Application no: 22/00959/REM

Location: East Of Last House Adjoining And North Of Berry Hill Road Adderbury

Transport Development Control

Oxfordshire County Council, as the Local Highway Authority, **object** to the approval of this Reserved Matters application.

BERRY HILL ROAD, ADDERBURY - DRAFT SITE LAYOUT

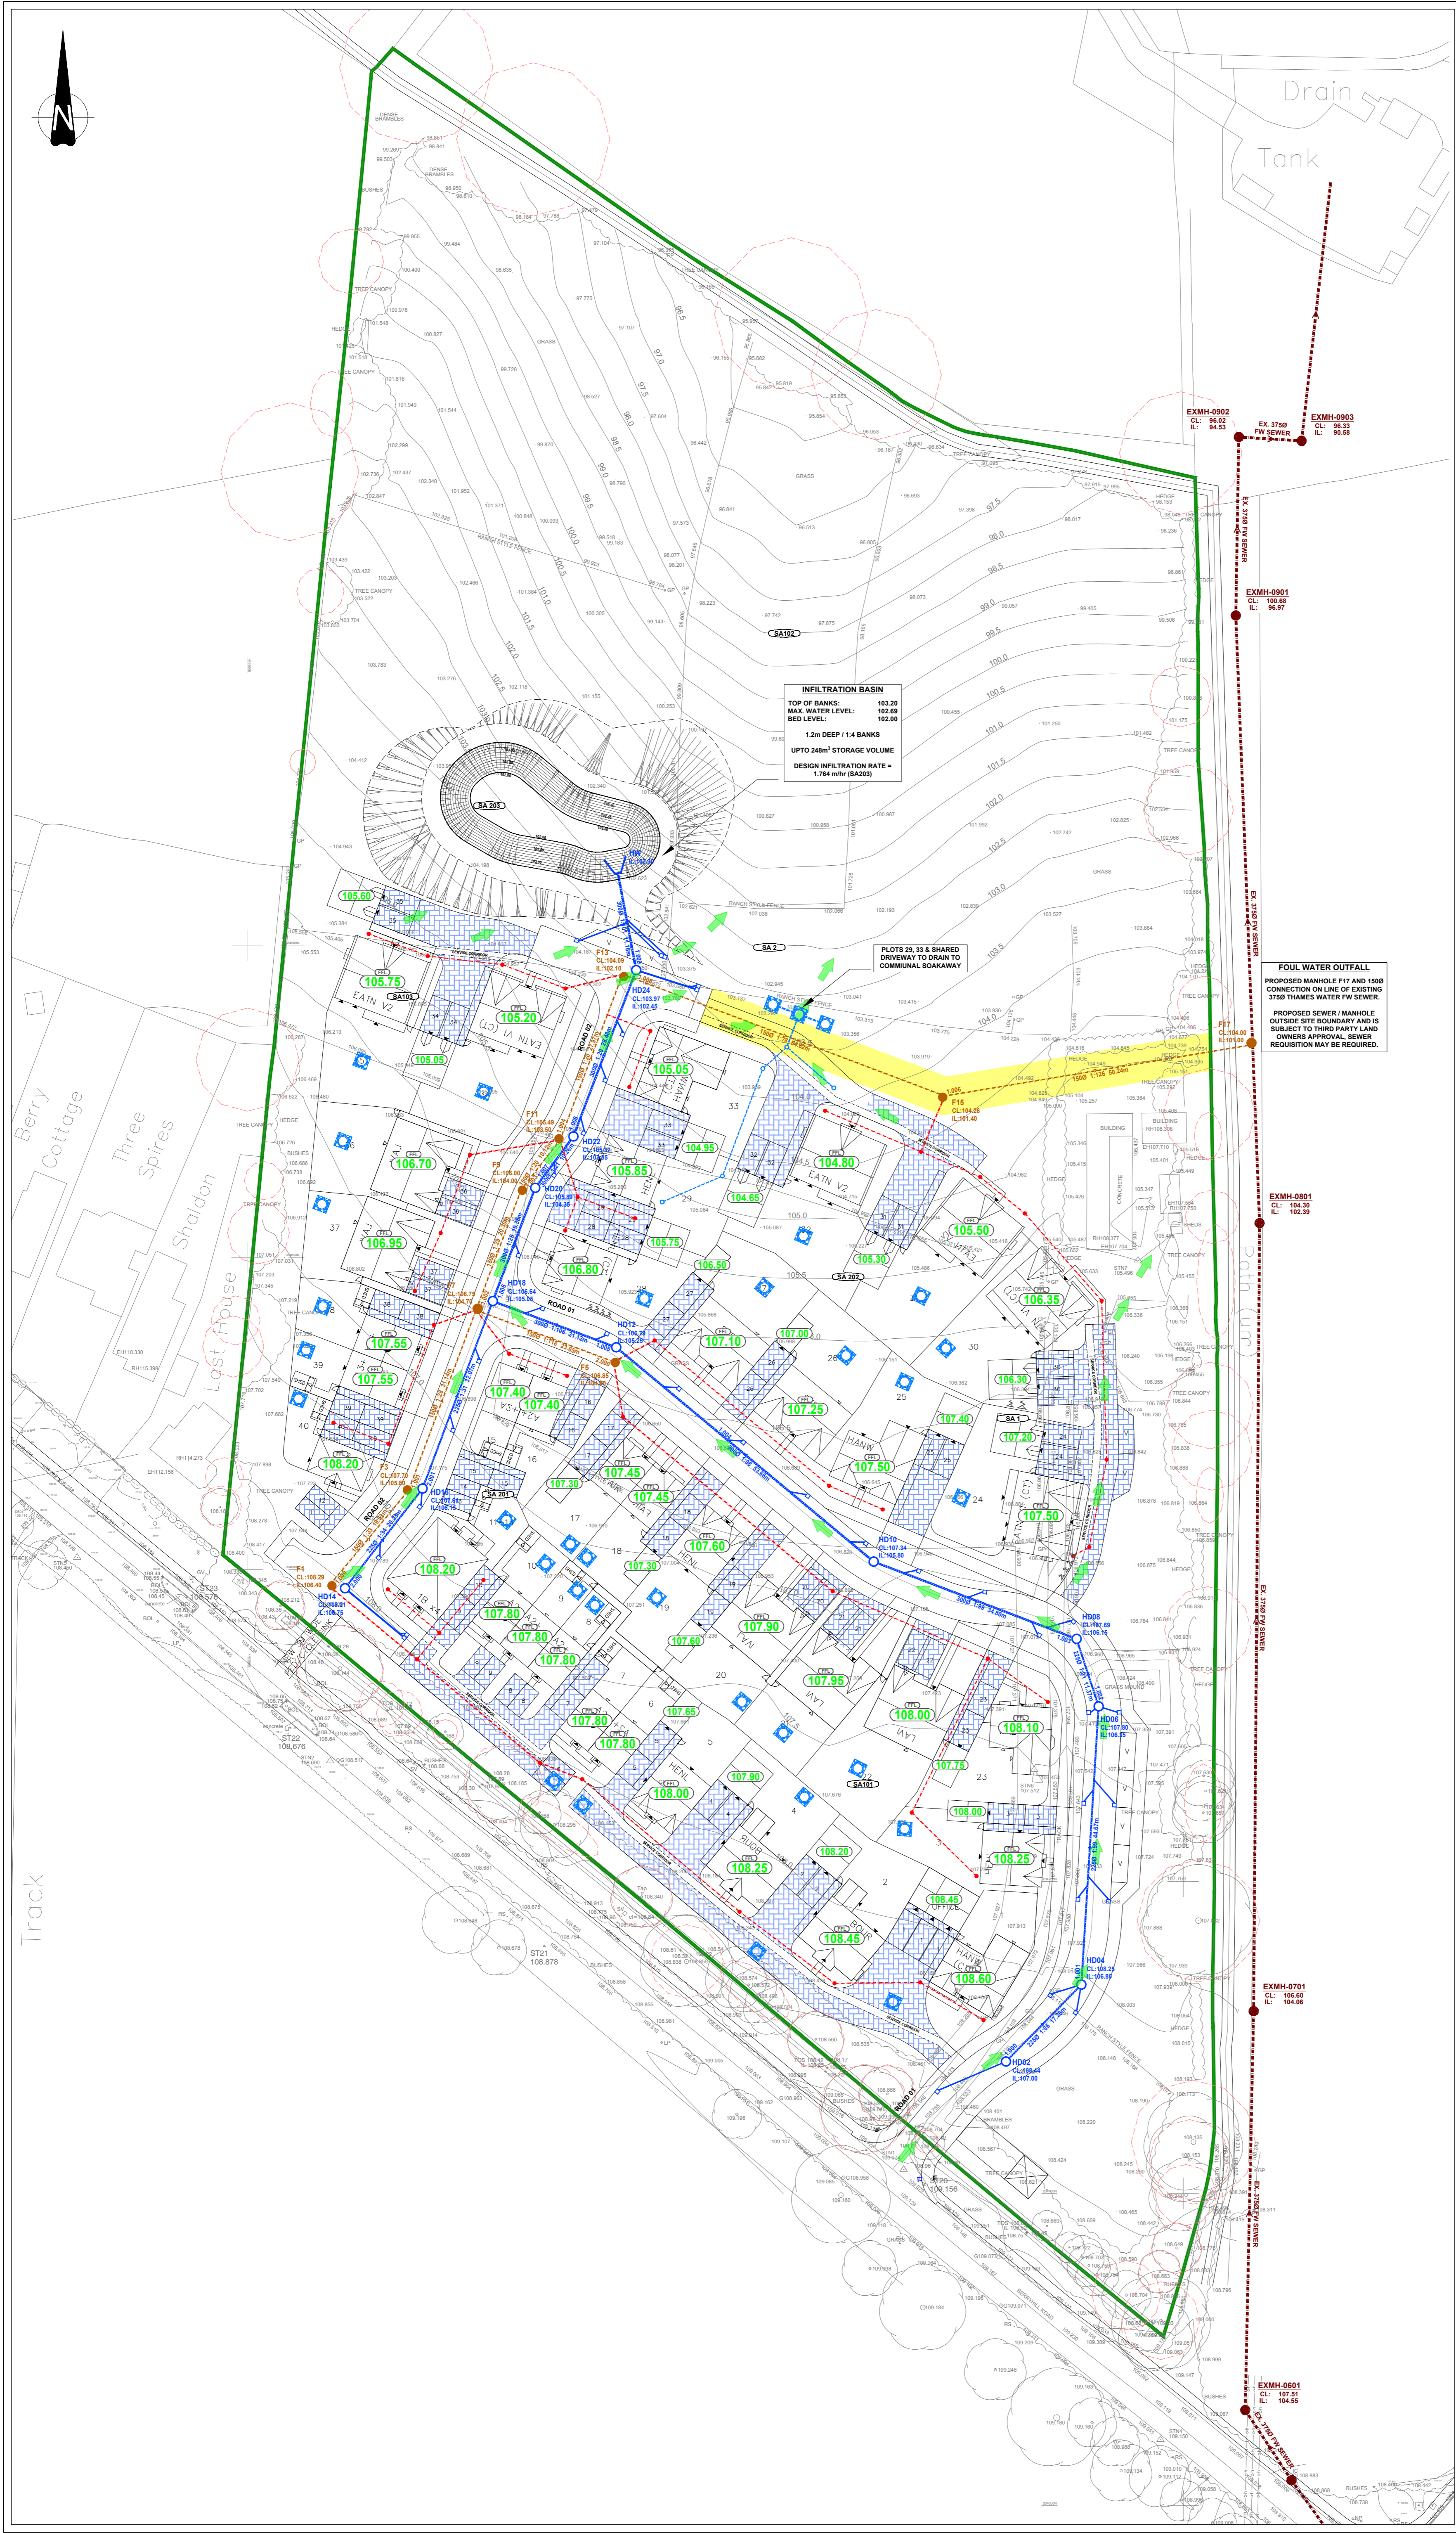
Footways: There should be a 2m footway either side of the road where there are properties on both sides. This is to ensure both safety and accessibility for people living in all properties on the site.

Landing Spots: Where the section of 1:20 longitudinal gradient is present there will need to be flat landing spots.

Visitor Parking: The visitor parking spaces within this development do not conform to OCC guidance in relation to dimension. Parallel parking spaces should measure a minimum of 2.5m x 6m to accommodate for all private vehicles.

Swept Path Analysis: A new swept path analysis will need to be produced and submitted for approval, the requirement of an additional 2.0m footway and the widening of the visitor spaces means that the current data is likely to be outdated.

Bin Stores and Refuse Collection Points: Details of bin storage or refuse collection points have not been detailed by the applicants. An area for bin storage must be identified on every property to ensure there is adequate space and demonstrate that they are not going to spill onto the highway. Refuse collection points will be needed at the end of each private drive as a refuse truck will not drive into these areas.

There is currently insufficient footway provision within this site. There should be a 2m footway on either side of the road where there are properties on both sides. This is to ensure the safety and improve the accessibility for people living in all properties within the development.

Where the section of 1:20 longitudinal gradient is present there will need to be flat landing spots. OCC's inclusive mobility guidance states that 'even if there not a pedestrian route in excess of 1:20, it is important that there are level sections or landings at regular intervals to provide people with an opportunity to rest.' A level landing must be provided for every 500mm that a route rises.

Property 1 has been allocated 3 designated vehicle parking spaces as well as a garage, as mentioned above, this will need to be addressed. However, when assessing the site layout, they are blocking the sales office access points. I would therefore recommend that the layout of this parking is revisited to ensure the offices are more accessible for all users.

The dimensions and the amount of visitor parking is insufficient when referring to OCC policy. OCC's Parking Standards for New Developments states that parallel parking bays should measure a minimum of 2.5m x 6.0m for safety and manoeuvrability, the spaces within this development only measure at a width of 2.0m. Within OCC's draft for Vehicular and Cycle Parking Standards it takes an approach that consistent with national research suggesting that within areas that have allocated parking "it may be appropriate to allow for additional demand for visitor parking of 0.2 spaces per dwelling" (DCL, 2007, Residential Car Parking Research). Using this information, this development requires 8 visitor spaces.

Details of bin storage or refuse collection points have not been detailed by the applicants. An area for bin storage must be identified on every property to ensure there is adequate space and that they aren't going to spill onto the highway, again these must have unobstructed access. Refuse collection points are required at the end of each private drive, as a refuse truck will not drive into these areas

- A section 278 application will be required for the access works.
- It is not clear if the access arrangement track as the kerbs have not been indicated.
- Where the section of 1:20 longitudinal gradient is present there will need to be flat landing spots.
- Adoptable visitor parking bays must be 2.5m in width.
- There should be a 2m footway either side of the road where there are properties on both sides.

BERRY HILL ROAD, ADDERBURY - LAVINGTON V1 ELEVATIONS AND FLOOR PLANS

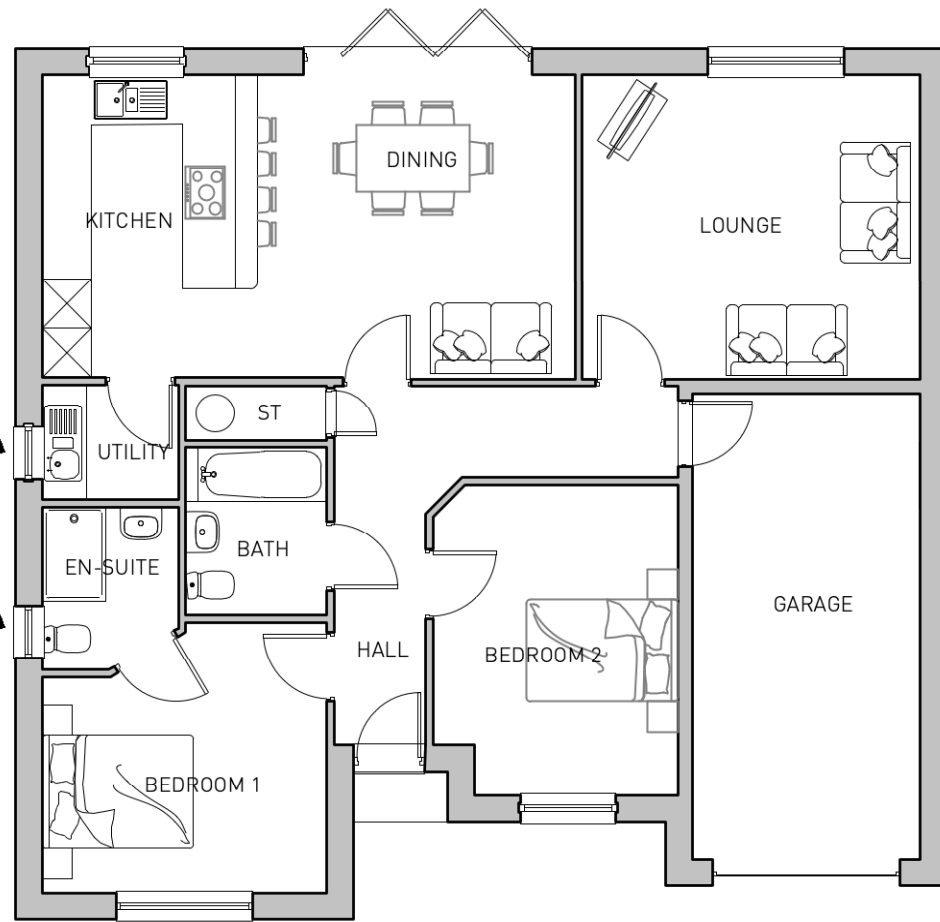
As mentioned above the Lavington, A1, A2 and A3 houses have all been designed without a garage and subsequently without cycle parking. It is stated within the OCC minimum parking standards that all new properties must allocate a certain number of cycle parking spaces per property. A1 properties should be allocated a minimum of 1 cycle space per property, with Lavington, A2 and A3 properties being allocated a minimum of 2 cycle spaces per property. Manual for Streets Chapter 8.2 states 'Providing enough convenient and secure cycle parking at people's homes and other locations for both residents and visitors is critical to increasing the use of cycles. Therefore, this issue needs to be addressed. Cycle parking should also be covered and secure, this is addressed by the cycle parking condition within the conditions section.

BERRY HILL ROAD, ADDERBURY - STRATFORD ELEVATIONS AND FLOOR PLANS

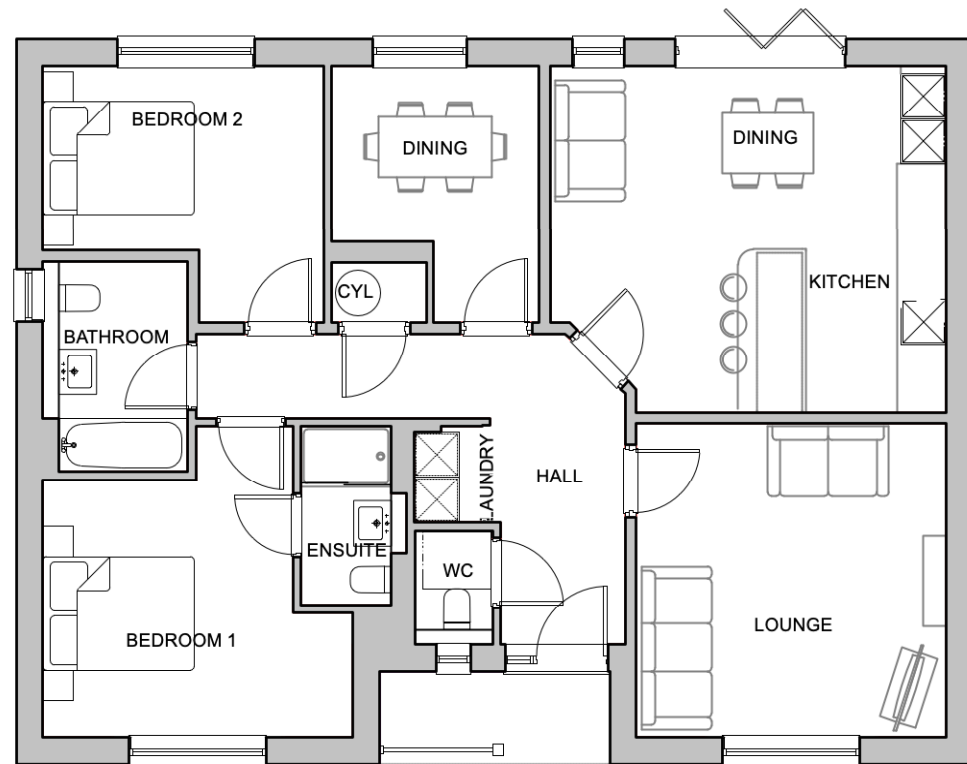
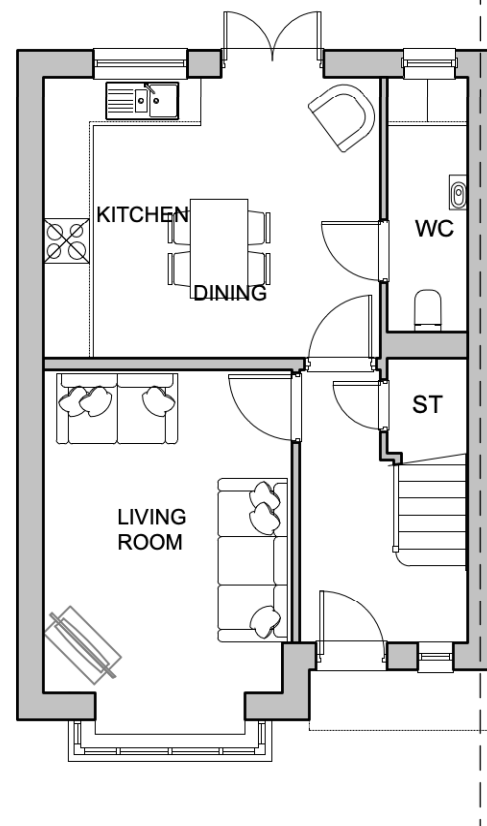
The 3-bed properties within this development (Stanton, Stratford, Fairford) have been designed with a garage measuring at approximately 3m x 6m. When referring to OCC's Parking Standards for New Developments it states that for a garage to classify as a vehicle parking it must measure 3m x 6m. Using this information and referring to OCC's maximum parking standards, the above-mentioned properties exceed the maximum number of allocated parking spaces for 3-bed properties. I would therefore recommend that the garage is reduced in size, removing its classification as a parking space, or design them in a way that makes them exclusively for cycle parking and general storage. In addition to this, properties 22 and 31 have been allocated 3 spaces as well as a double garage. Again, when referring to the OCC parking standards, this exceeds the maximum number of spaces permitted for a 5-bed property and will need to be addressed. The concern here is that this leads to a 'car based' development, where car use is encouraged as the most convenient and desirable option of travel, something OCC is trying to shift away from.
